## MMC Congress Street building

Glenn Fenton <gfenton@gpmetro.org>

Tue, Nov 13, 2018 at 3:13 PM

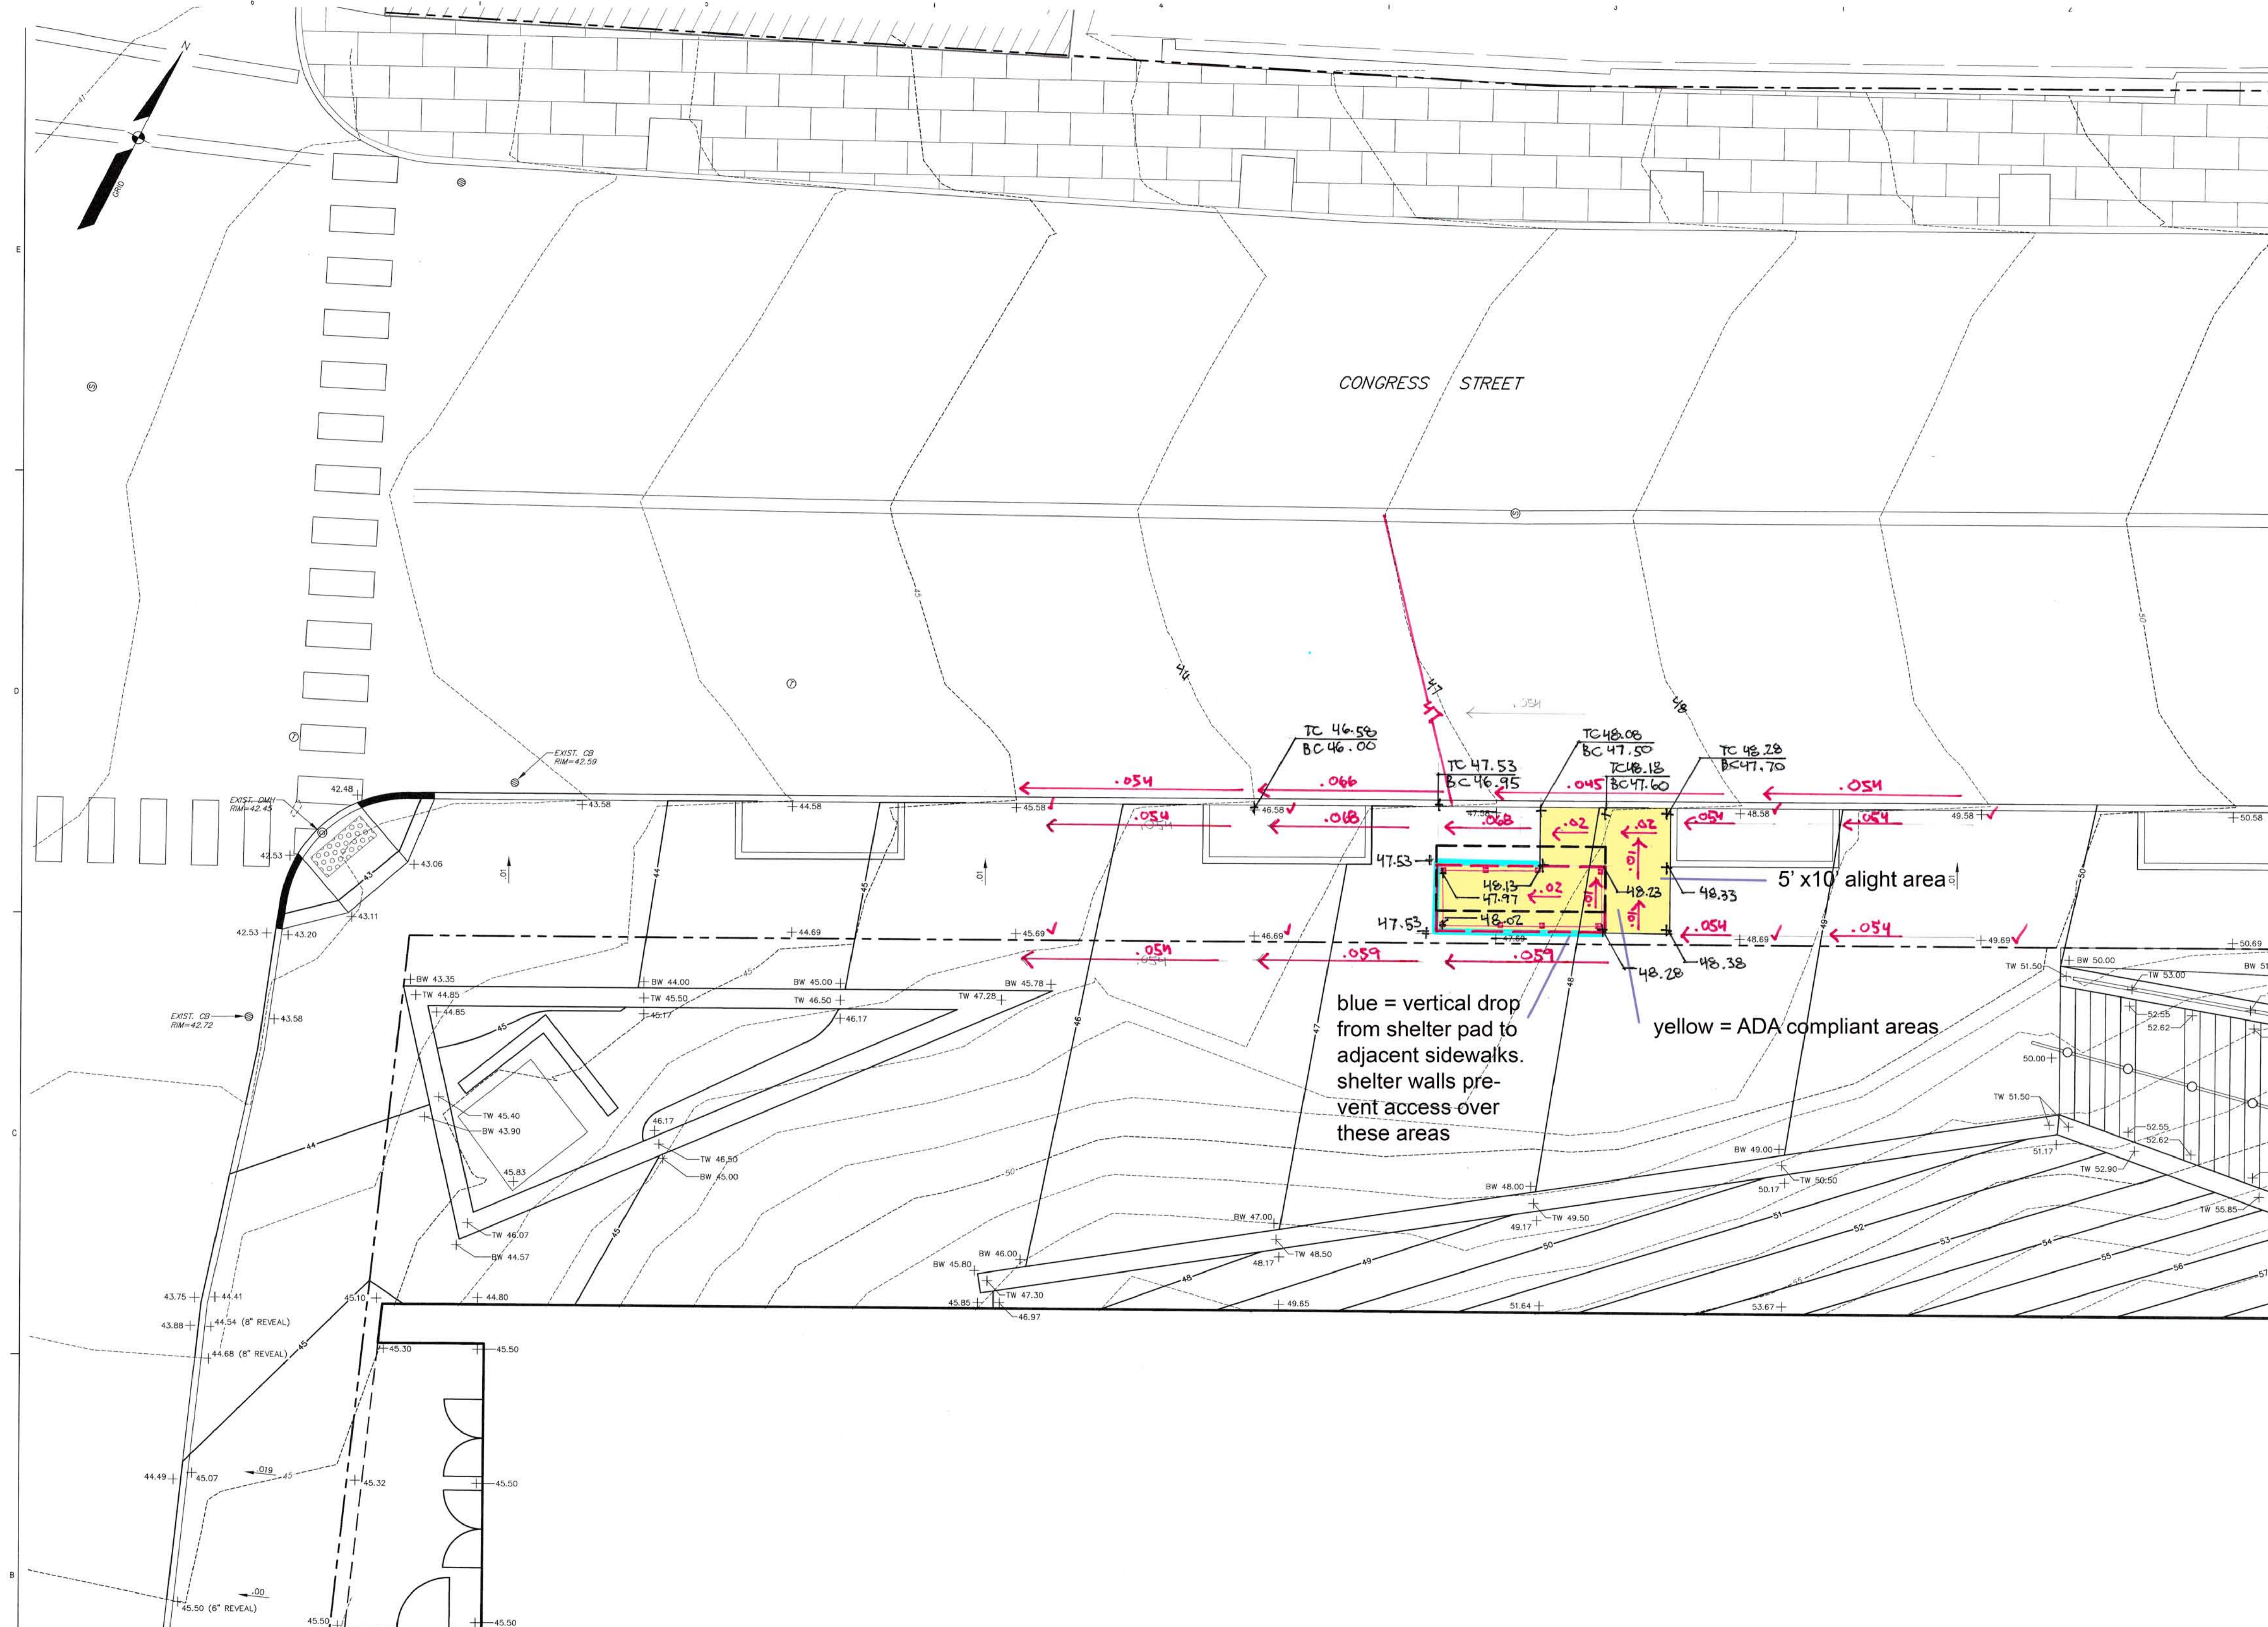
I would like clarify Metro's position on the proposed changes to the bus stops near Maine Medical Center. We would prefer to see the new bus stops be located further east than the current plans indicate. Ideally, the new bus stops would have better access to the new entrance to the building (without having to climb a large staircase). Additionally, the stops would be best located close to crosswalks (on the far-side). It has been in Metro's plan to consolidate the bus stops at Gilman/Valley and Weymouth St, which are in bad locations, to one more central location closer to Maine Medical.

At the bus stops we'll require a 5' x 8' landing space for boarding passengers using the ramp. We'd like to avoid planter boxes or tree-wells close to the bus stops as the create tripping hazards. It is preferred that both bus stops have Duogard 5' x 9' bus shelters, which is Metro's standard shelter. This keeps the cost of maintenance down. However, we're open to other shelter concepts as long as they meet ADA regulations, Safety/Security concerns and Maine Medical assume full responsibility for maintenance.
